### **Durham County Council reference number: 20032071**

### **Durham County Council's Response to Examination Document PDL-013**

Route Alignment

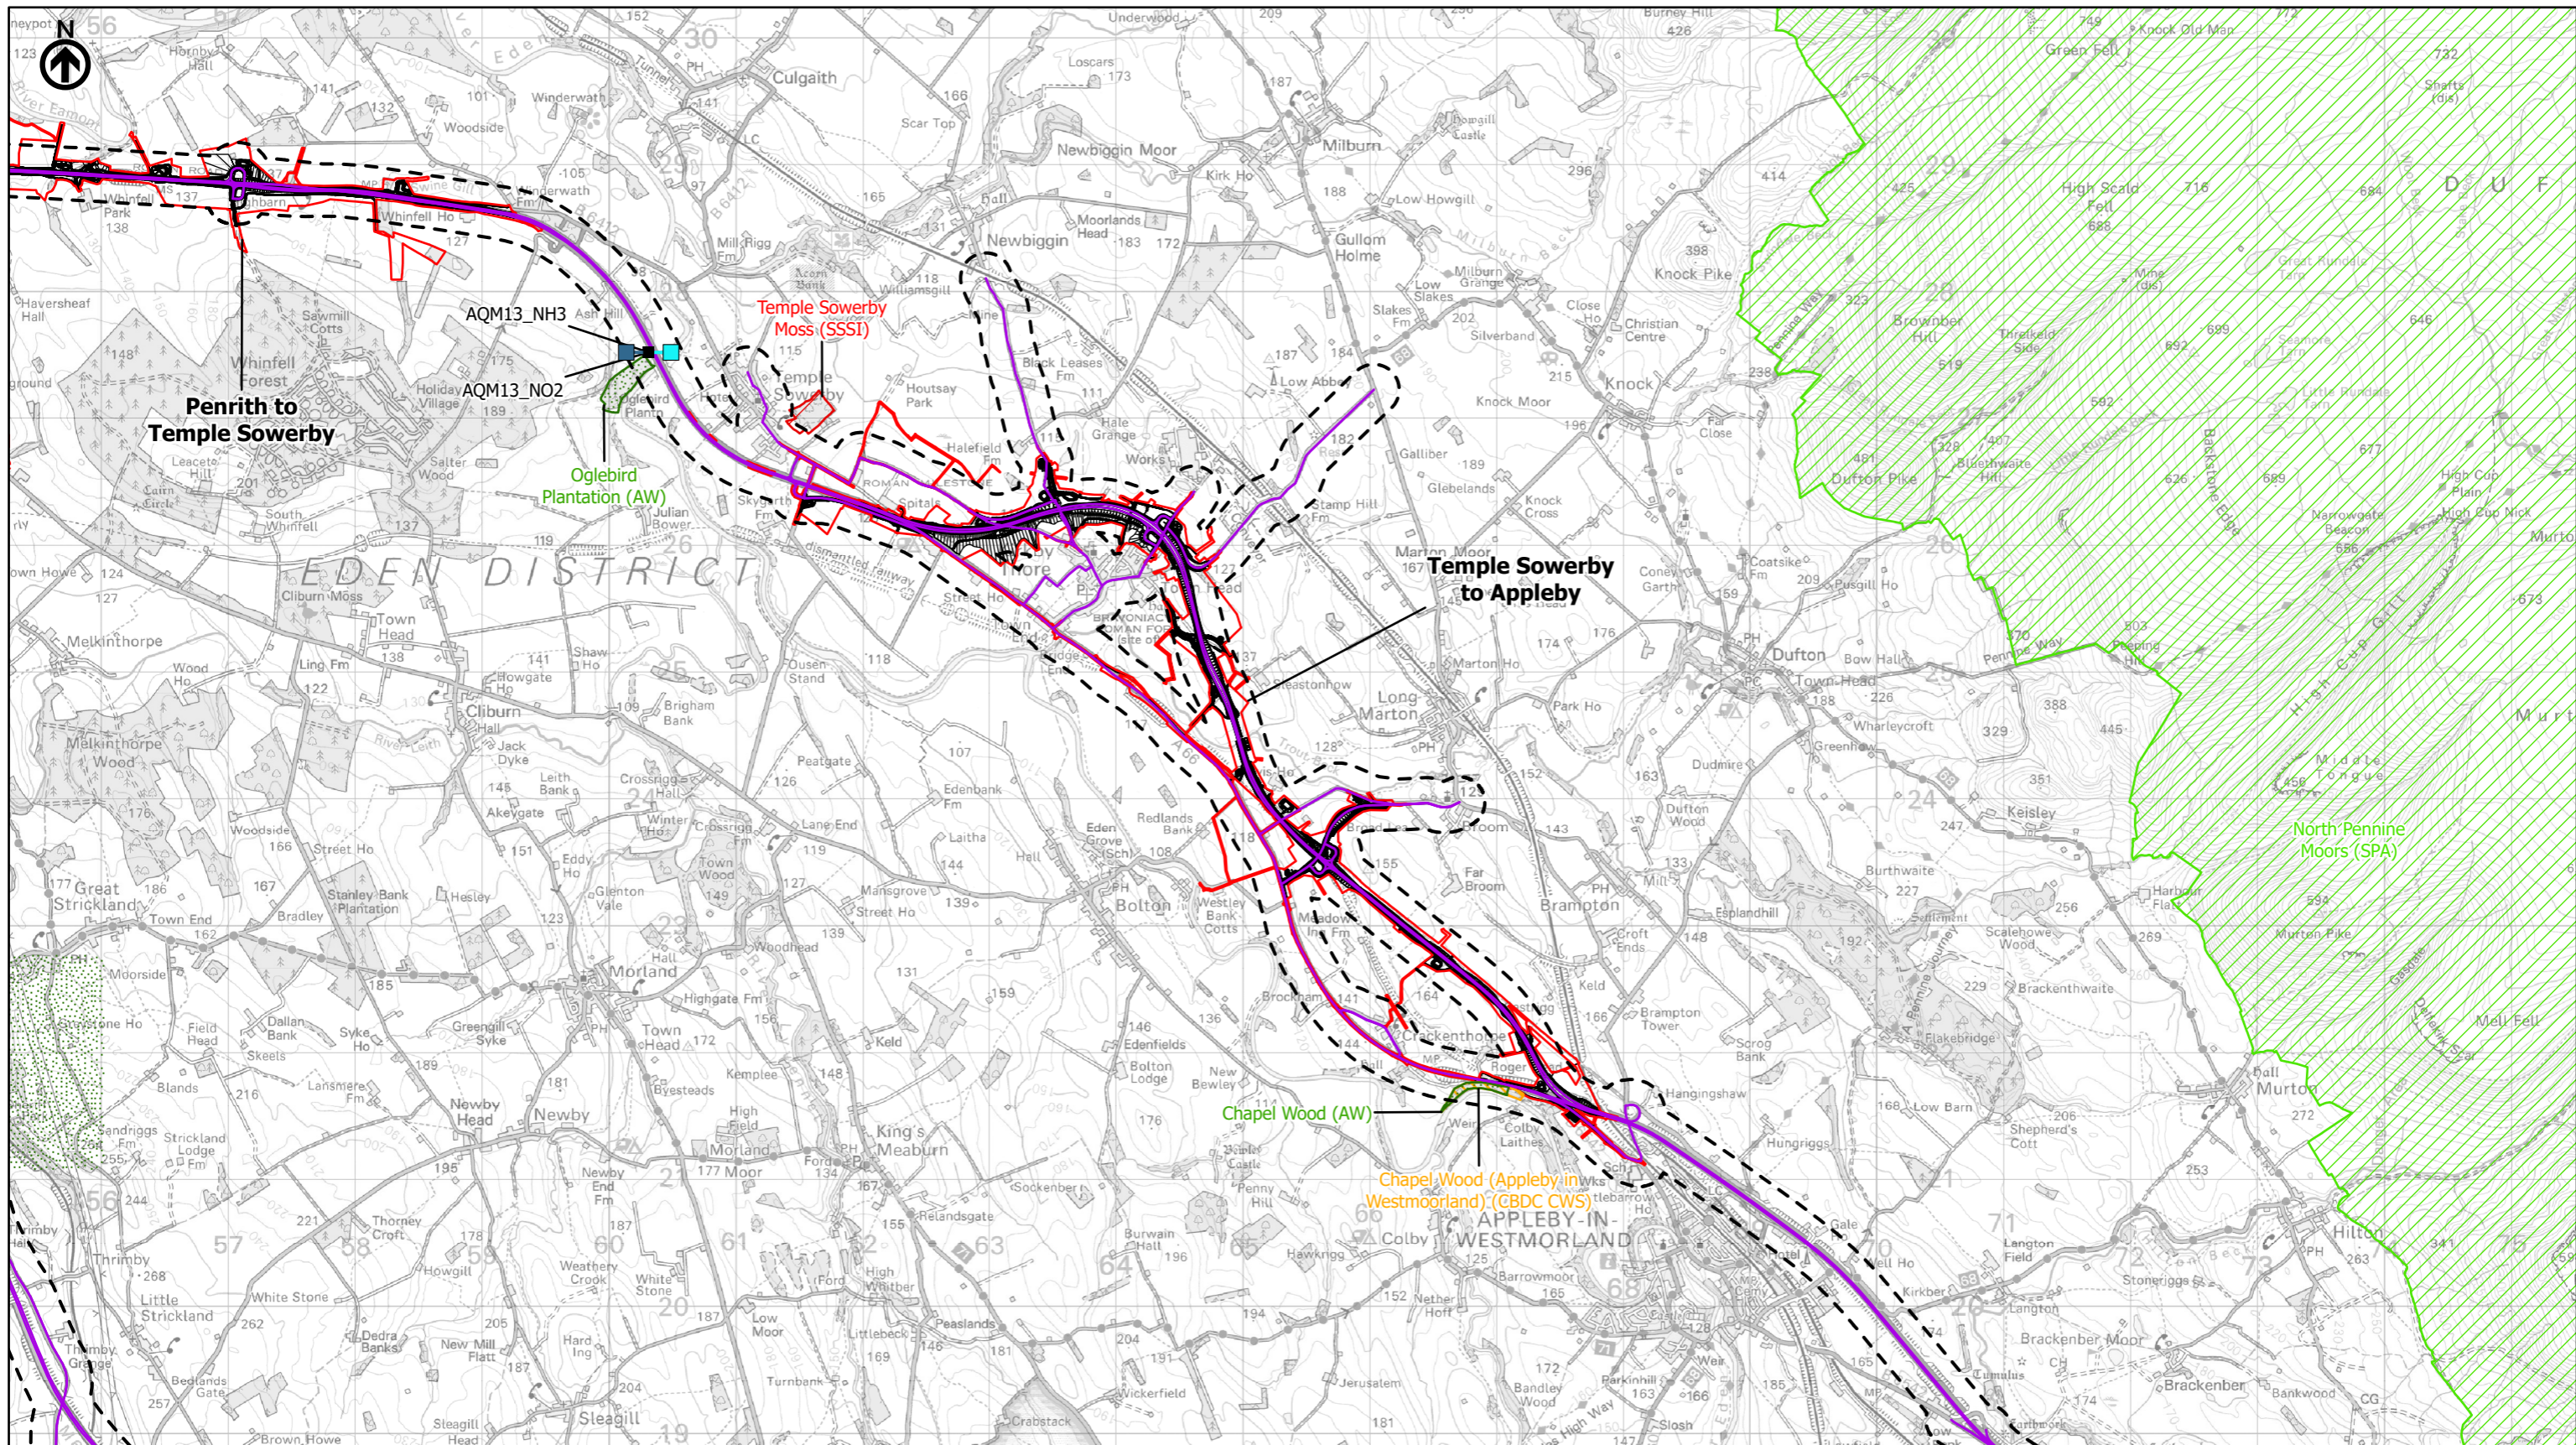
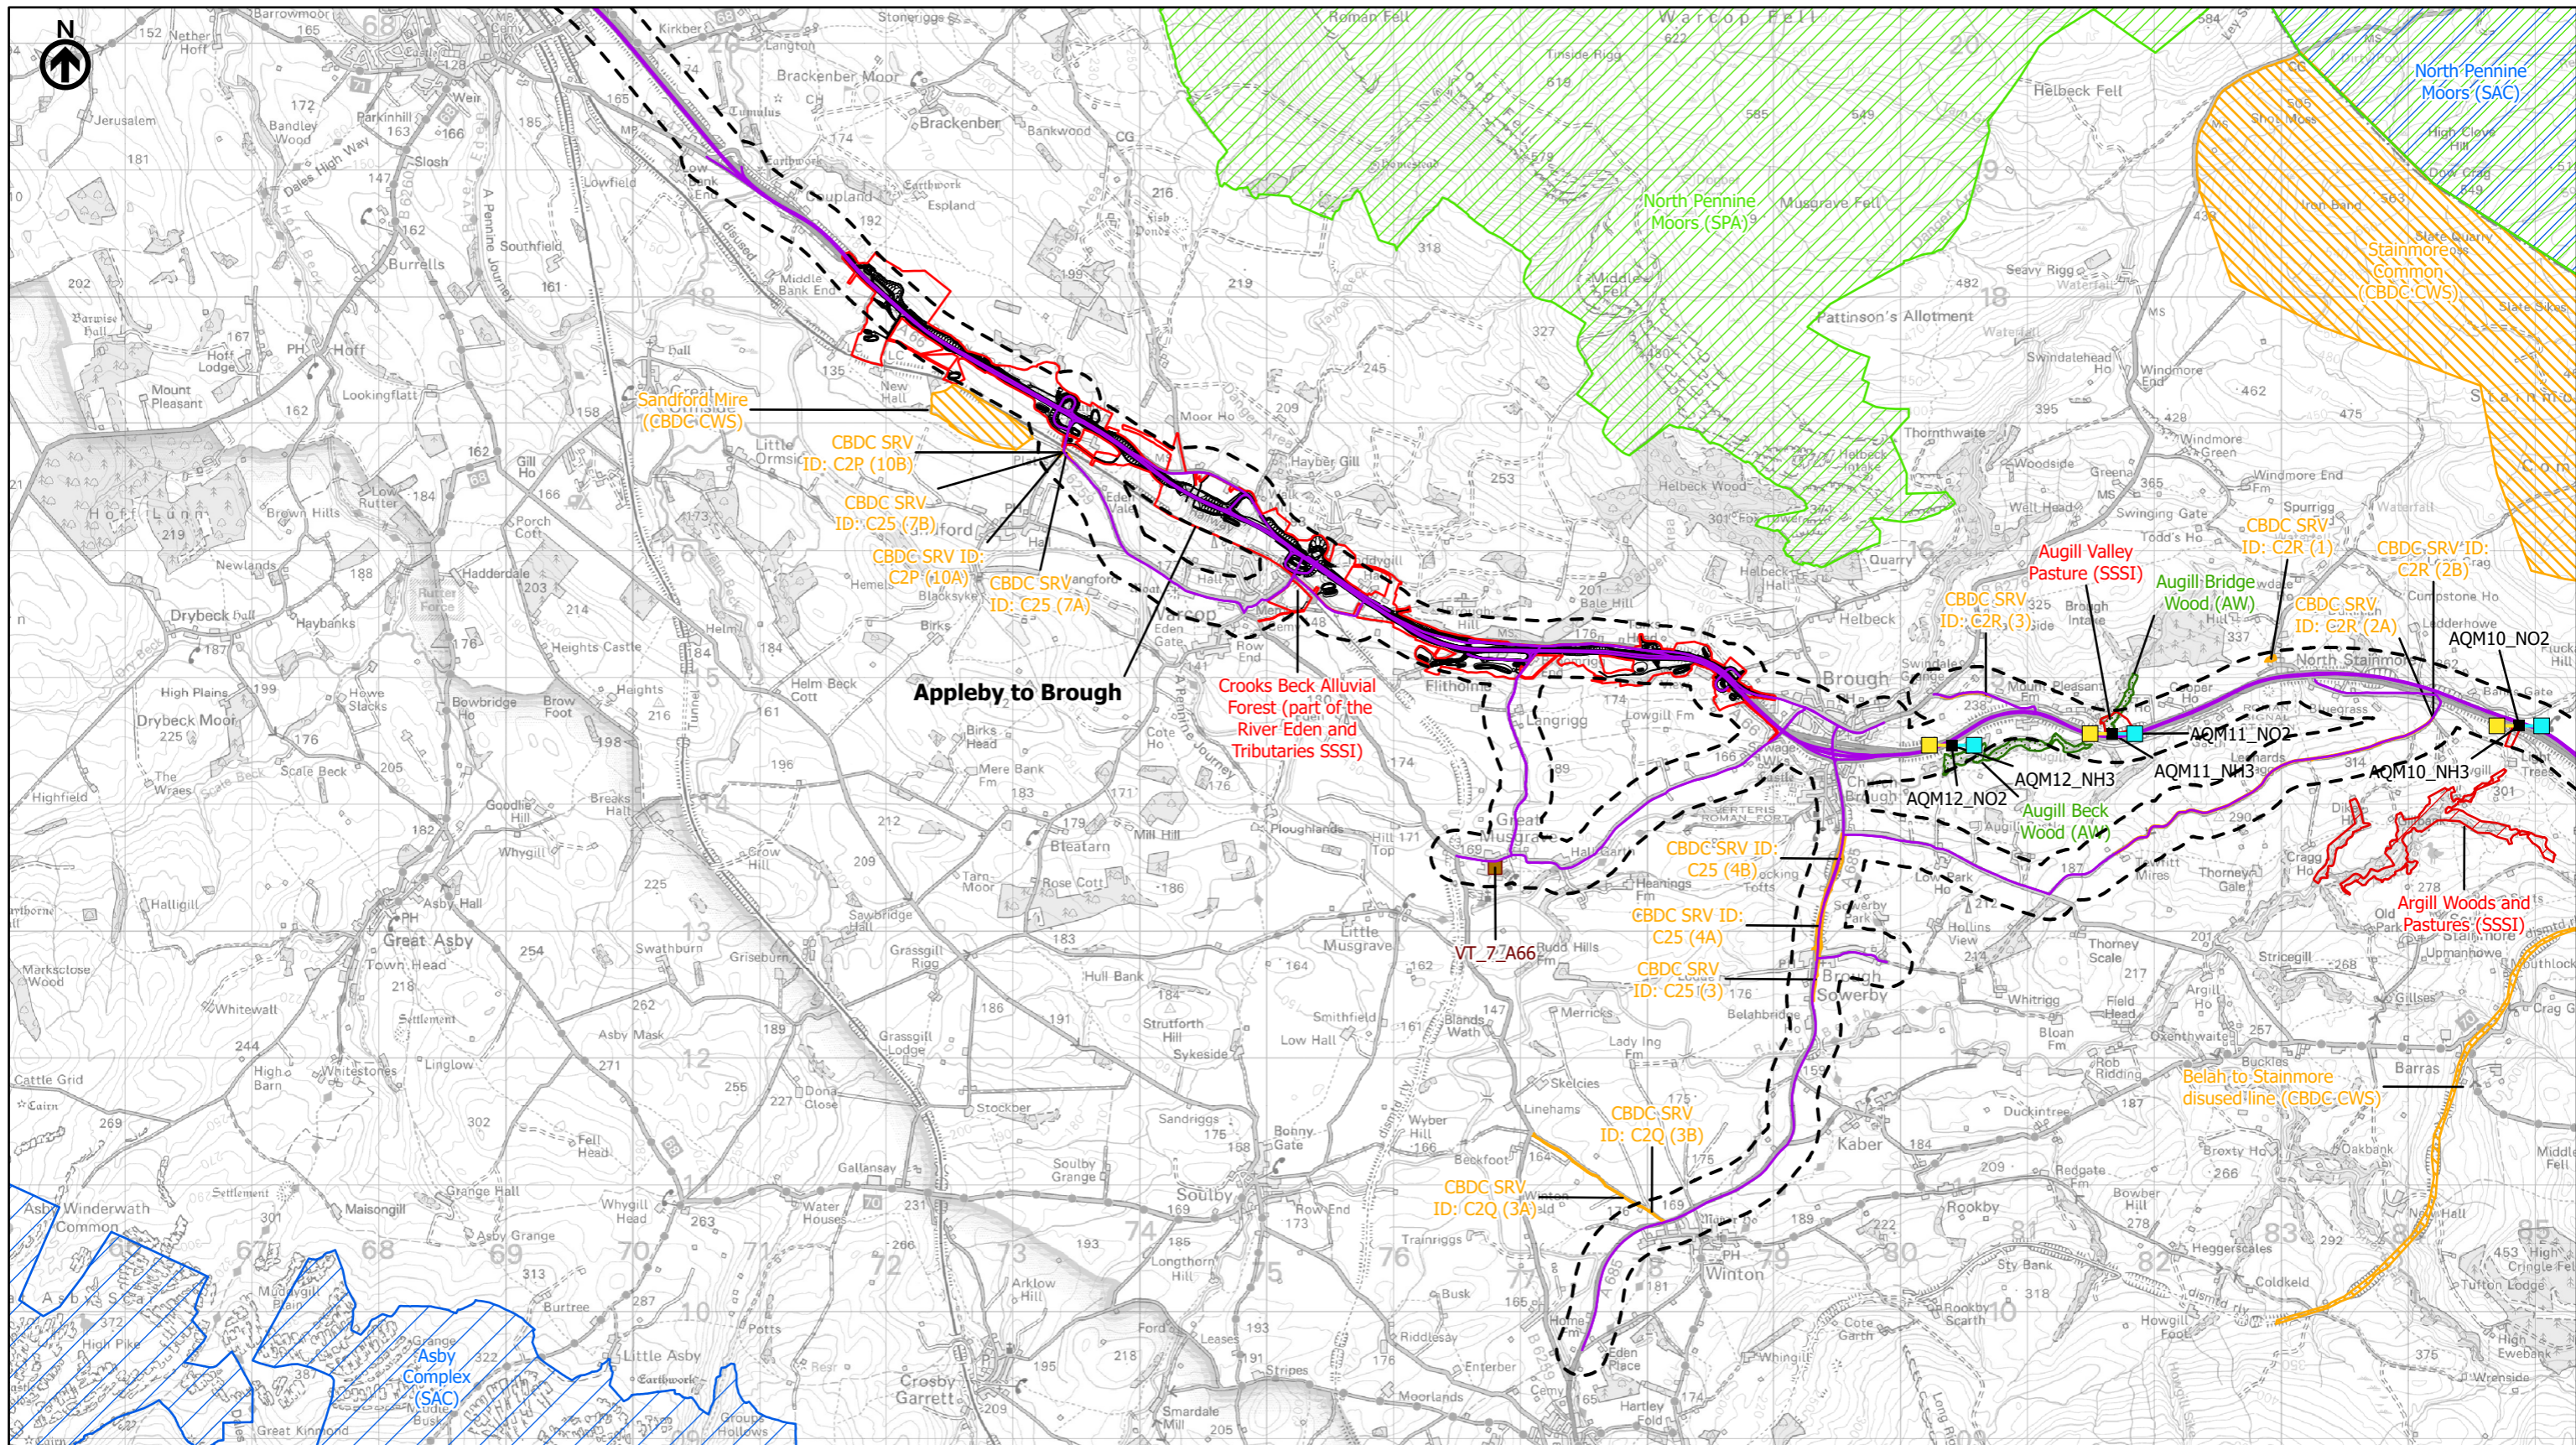
DCC response 31.08.2022	Applicant response 16.11.2022	DCC response 24.11.2022
Baseline		
<p>Baseline NO2, PM10 and PM2.5 have been presented in Appendix 5.3 Air Quality Baseline Monitoring. No Scheme specific PM10 or PM2.5 monitoring has been undertaken and it is noted that there is no nearby existing PM10 or PM2.5 monitoring in the study area within DCC. These three pollutants have been assessed for both construction and operational phases.</p>	<p>Preamble, no response necessary.</p>	<p>No further comment.</p>
<p>DCC air quality baseline has not been reported specifically to inform the baseline appreciation however considering the distance to the DCC air quality monitoring locations, this is not considered a material issue.</p>	<p>Duly noted.</p>	<p>No further comment.</p>
<p>Four months of NO2 monitoring was undertaken for the Scheme between November 2021 to February 2022 at 16 NO2 locations in triplicate; four of these locations were in DCC (AQM 5, 6, 7 and 8). DCC were not consulted on the locations or given the opportunity to provide insightful, local feedback on the locations where monitoring would be useful. Based on the level of impact indicated by document 3.7 Transport Assessment in both construction and operational phases, it would have been useful to monitor at a sensitive receptor location along the A67 in Barnard Castle, near the river bridge, where a number of dwellings are located at locations nearby the road edge.</p>	<p>The NO2 monitoring locations were informed by the findings of the Preliminary Environmental Information Report (PEIR) and were undertaken at locations where the preliminary assessment identified the likelihood of significant effects. The comments provided, relating to monitoring locations in Barnard Castle, are noted.</p>	<p>We have outstanding concern of potential air quality impact at sensitive receptors in Barnard Castle due to lack of project monitoring data. Monitoring data in Barnard Castle would be helpful to understand the air quality impact risk and assist inform key method points the assessment has taken.</p>

<p>There is no source of background nitrogen deposition rates used in the assessment provided in Appendix 5.3 Air Quality Baseline Monitoring. As per LA 105, this should be included in any reporting.</p>	<p>Background nitrogen deposition rates for the ecological sites identified in the assessment were taken from Air Quality Information System (APIS) at the time of ES drafting and assessment, as set out in Chapter 5 Air Quality (Document Reference 3.2, APP- 048) (Current Baseline - paragraph 5.7.3).</p>	<p>No further comment.</p>
<p>Defra annual mean background pollutants concentrations have been used in the assessment for 2019 and future year 2029; in grid square contribution from major road sector emissions have been removed from the background NOx estimates. This is reasonable. A comparison between Defra modelled and local authority background NO2 monitoring data has been made; this showed that Defra backgrounds were slightly lower than local authority monitored data however there is no discussion on this other than the difference is small (1 µg/m<sup>3</sup>) and concentrations are below the objective, nor any consideration discussed of factoring the Defra predictions using the monitoring. Given the low levels of predicted model result concentrations, this will not likely materially affect the conclusions.</p>	<p>Reviewer statement, no response required.</p>	<p>There are a number of methodological assumptions in the assessment that we consider not to represent a reasonable worst case. Therefore, it is not clear whether reasonable worst-case assumptions would materially affect the conclusions of the assessment.</p> <p>An assessment taking into account a reasonable worst case here would have used the monitoring data to inform the background pollutant concentrations.</p>

<p><b>No DCC monitoring or National Highways monitoring within DCC boundaries has been used to verify the model outputs against measured data. It is further understood that none of the Scheme-specific monitoring has been used for verification. Discussion would be useful in this instance to present how representative the verification is of receptors within DCC.</b></p> <p><i>At this point it has been assumed that the applicant's numbering system has been disrupted and is incorrect. Comments have therefore been addressed from this point on, on this basis.</i></p>	<p>12 and 13. There are no DCC monitoring locations adjacent to the ARN (as noted by the Interested Party in comment (2) above which they acknowledge is not a material issue). Available data from a National Highways air quality monitoring station have been used for model verification. Several administrative areas are covered by the assessment study area which is predominantly rural in nature with pockets of urban settlements; overall, air quality is good. In addition to National Highways air quality monitoring data, the model was verified using local authority monitoring data from representative roadside locations adjacent to the ARN. As noted above in response to item (13), site typology was considered and two separate verification factors, one for urban and another for rural road links (and receptors), were derived and applied. Where possible, sites with ≥75% data capture were used; where this condition could not be met, in one instance, this has been noted. The verification using the rural zone for use</p>	<p>A reasonable worst-case and robust assessment should be undertaken. It is not considered a reasonable worst case to use an adjustment factor lower than 1 to adjust any dispersion model outputs, given the ADMS software's tendency to underpredict. Relying on an RMSE of 12.6ug/m<sup>3</sup> is not considered robust, based on the guidance referenced in the ES chapter, and it is recommended that the modelling and verification that informed the assessment of construction and operational phase impacts is revisited. It is also not considered a limitation of the assessment to not use more monitoring data locations. Should DCC not monitor in this area, project specific monitoring should have been</p>
